**Re: Mister Car Wash at 4703 Alameda Blvd NE
Erosion and Sediment Control Plan
Engineer's Stamp Date 6/21/24 (C17E002A26C)**

Based on the information in your submittal received on 6/26/24, the ESC plan cannot be approved until the following comments are addressed.

<div><div></div><div>CPESC Stamp</div></div>	Mister Carwash NM 2502		
	PROJECT TITLE		
	ALBUQUERQUE, NM, BERNALILLO COUNTY		
	CITY, COUNTY, STATE		
	02/05/2025	DATE	 INSPECTIONS PLUS
	B. Henriksen / J. Tolman	DRAWN BY

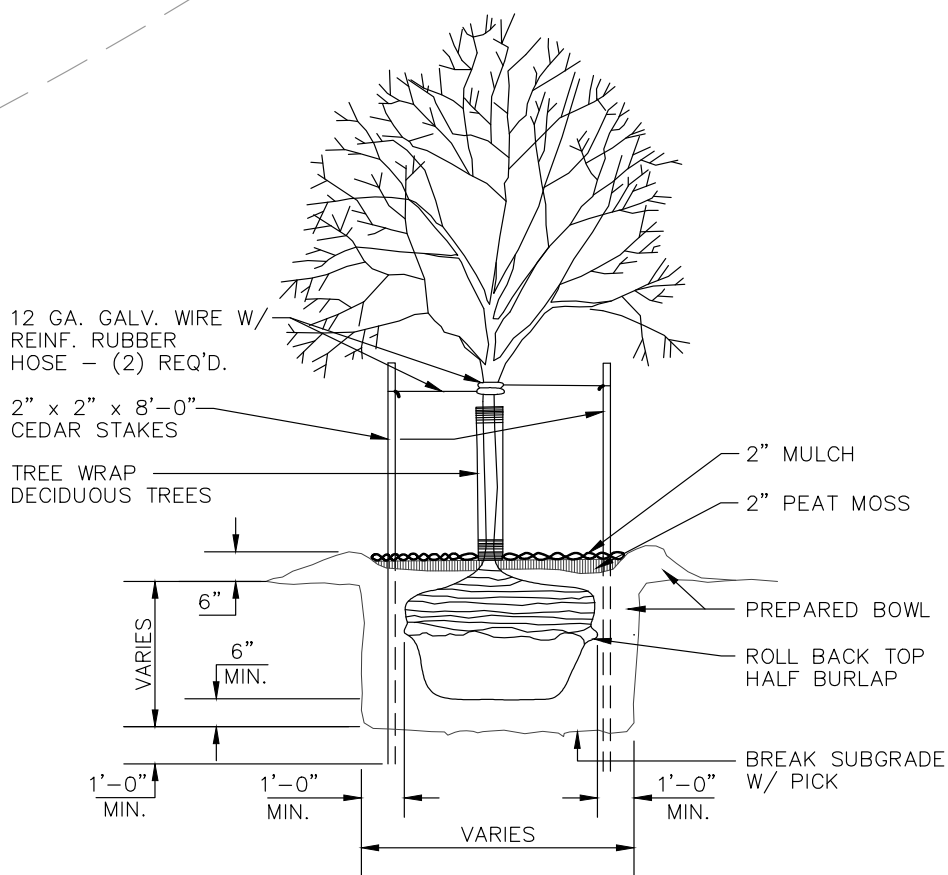
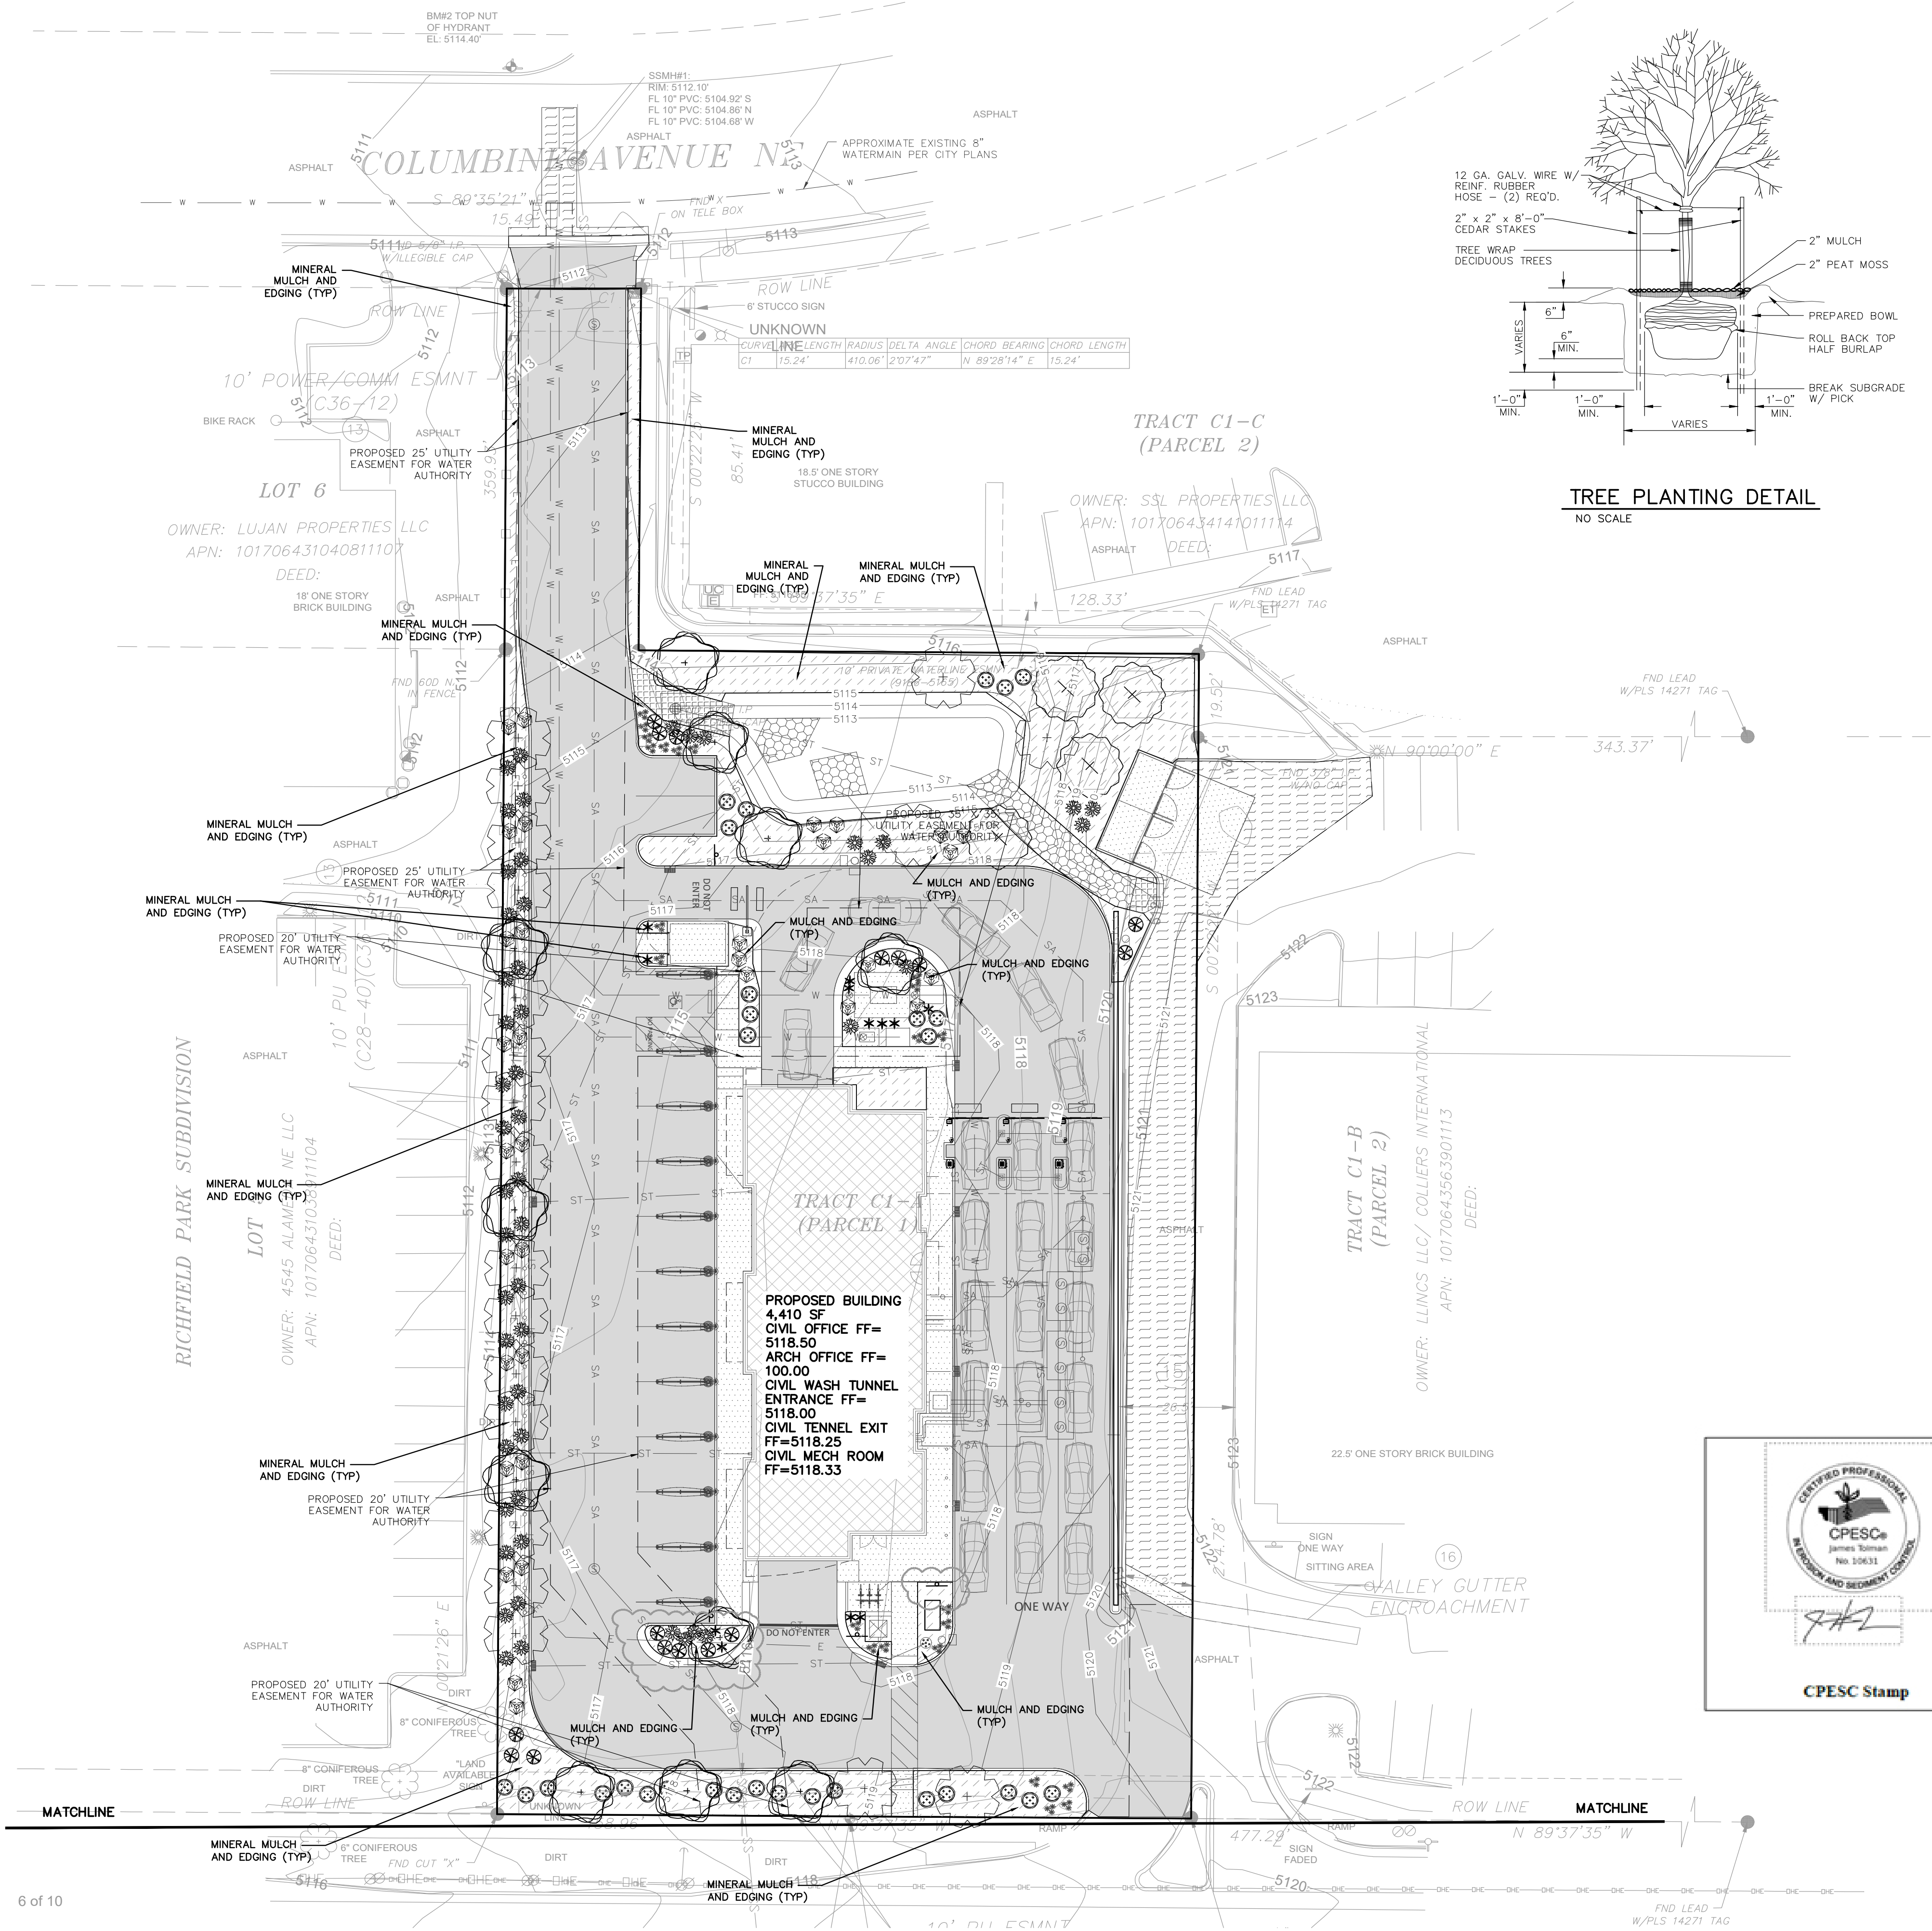
1. The ESC Plan can't be approved until after Hydrology approves the G&D Plan for each specific purpose, Site Plan, Grading, Building Permit, and Work Order. Hydrology has not yet approved the plan for any purpose. The existing and proposed grades must be shown on the ESC Plan, and they must agree with the Grading Plan approved by Hydrology (CGP7.2.4.b.ii);

4. Update the engineer's stamp date each time the plan changes.
